T-Mobile

T-MOBILE SITE NUMBER: DN04252A
T-MOBILE SITE NAME: AT&T SUNVIEW
T-MOBILE PROJECT: ANCHOR

BUSINESS UNIT #: 855798
SITE ADDRESS: 10410 STATE HIGHWAY 115
 IVYWILD, CO 80926
COUNTY: EL PASO
SITE TYPE: MONOPOLE
TOWER HEIGHT: 150'

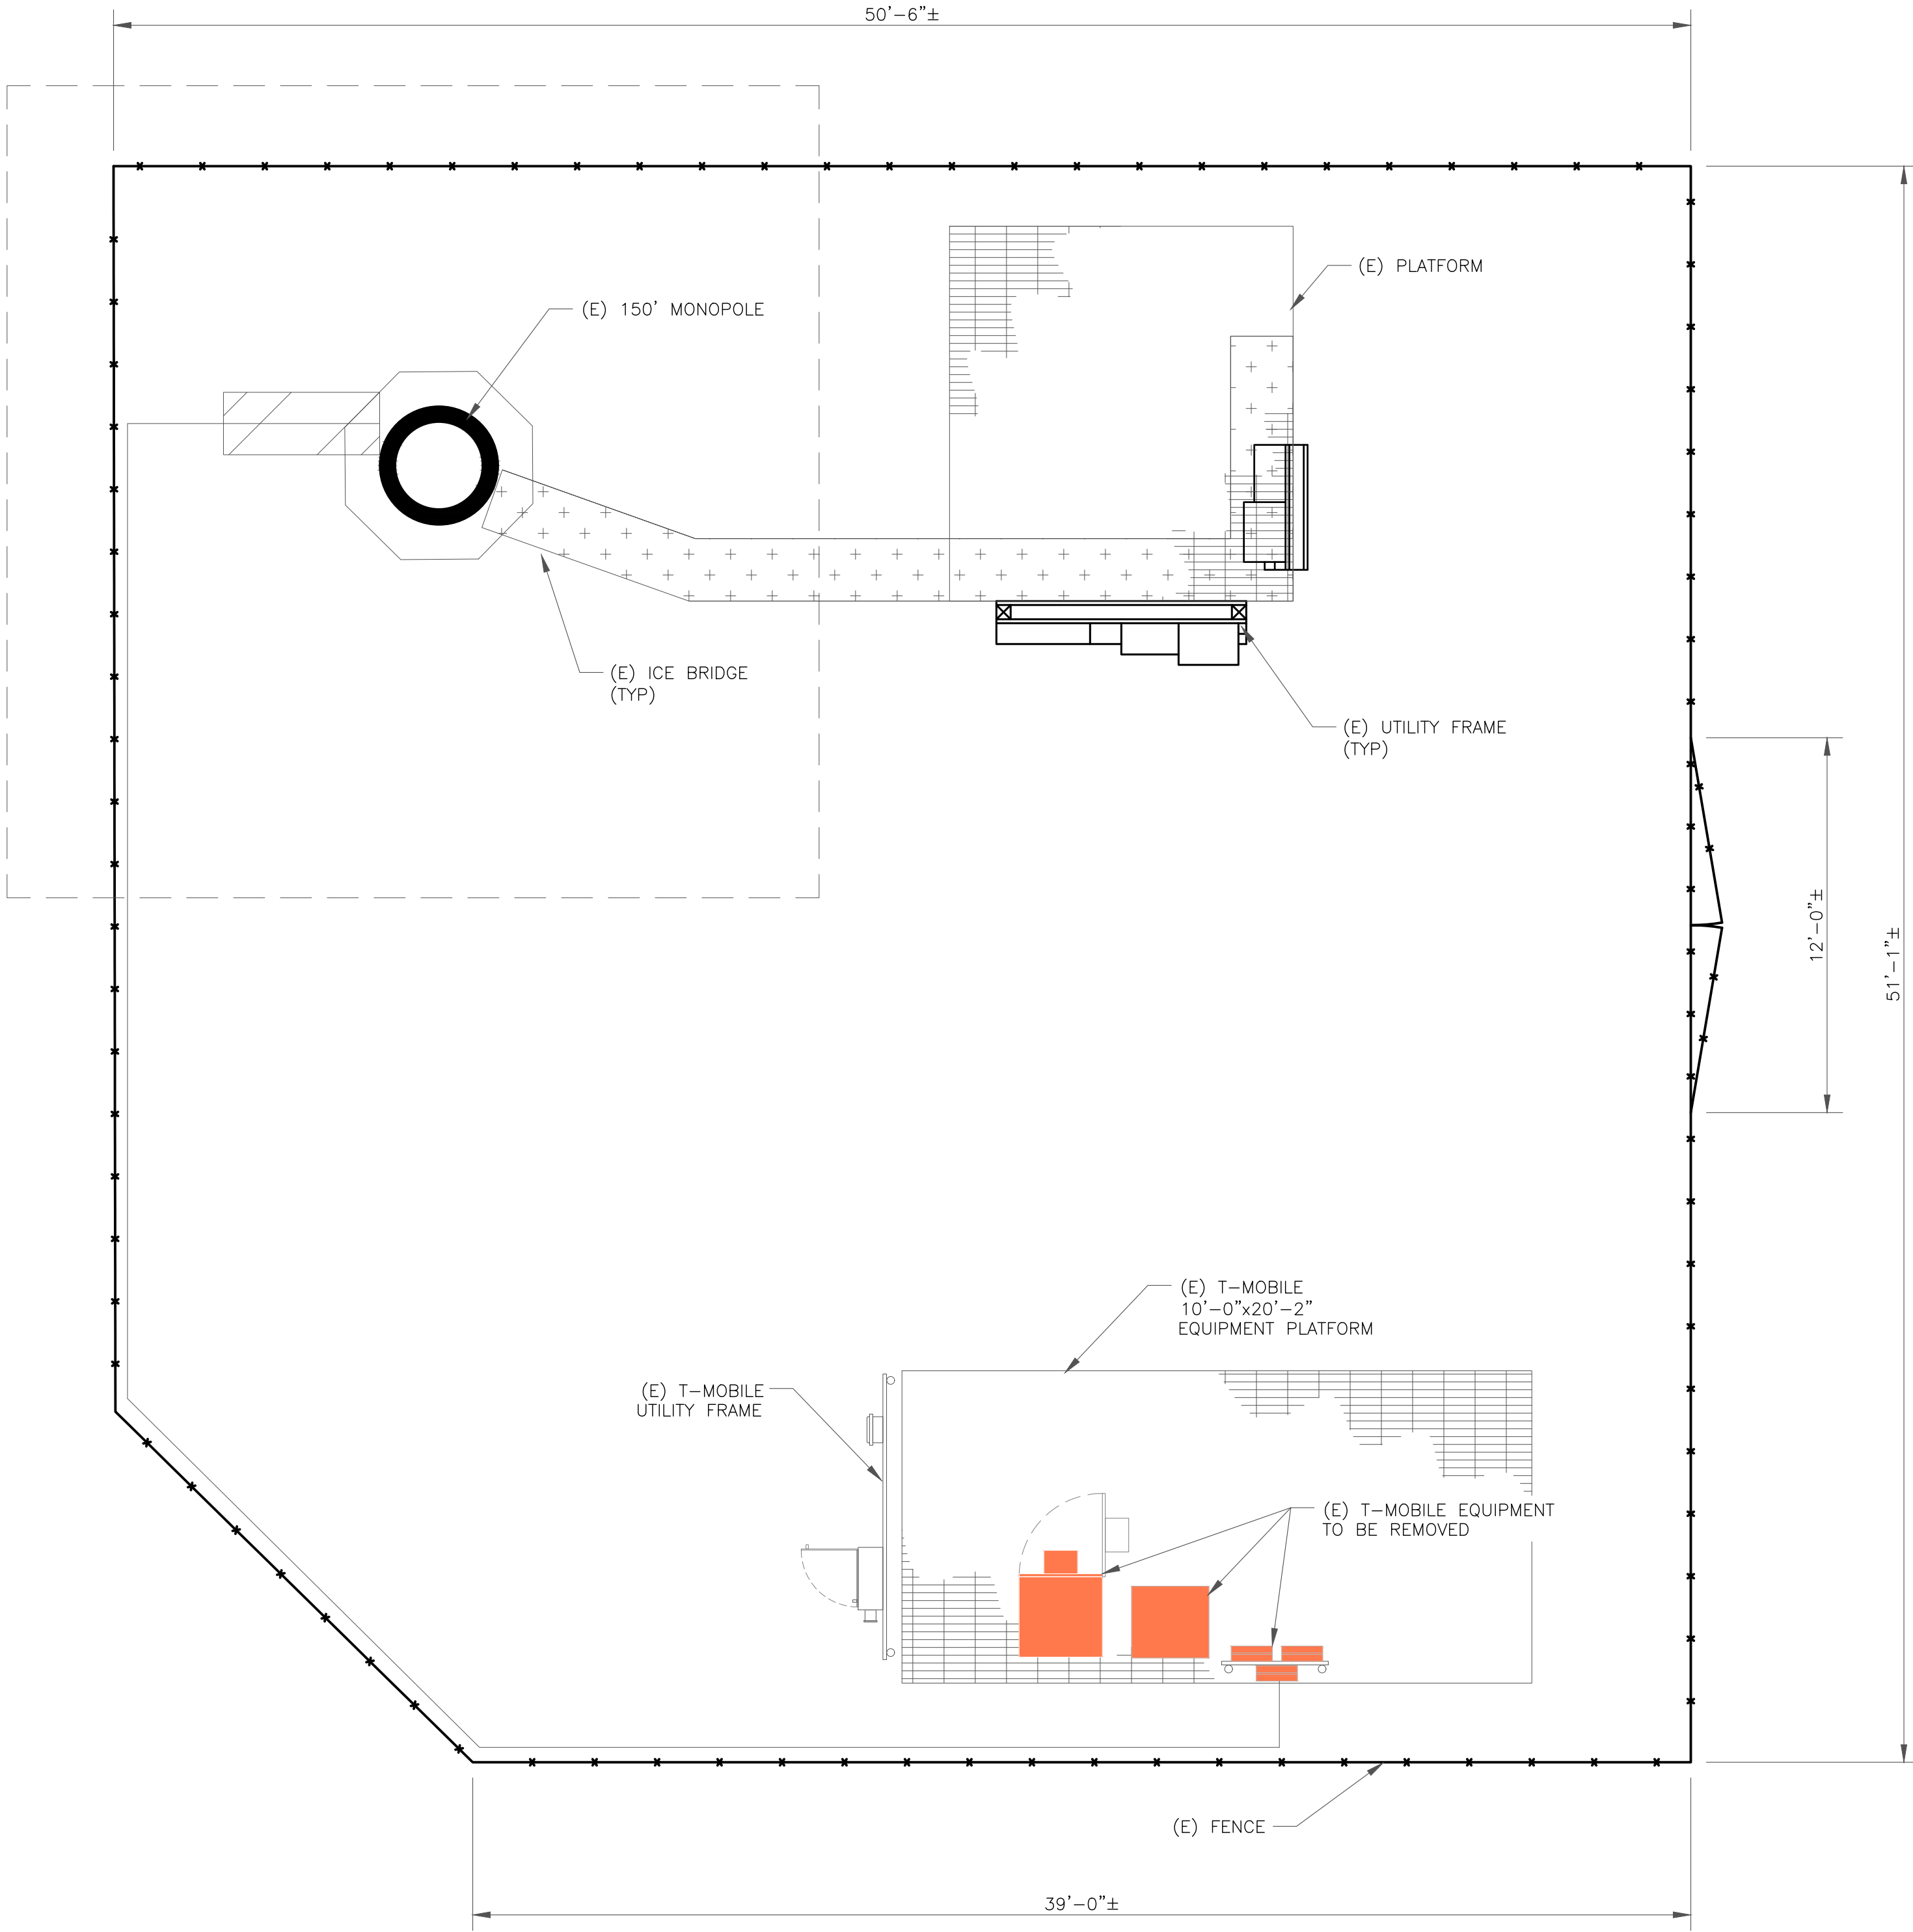
Please add a site plan showing the tower in relation to all property boundary lines as well as any easements on the property (please see the site development checklist uploaded with these comments)
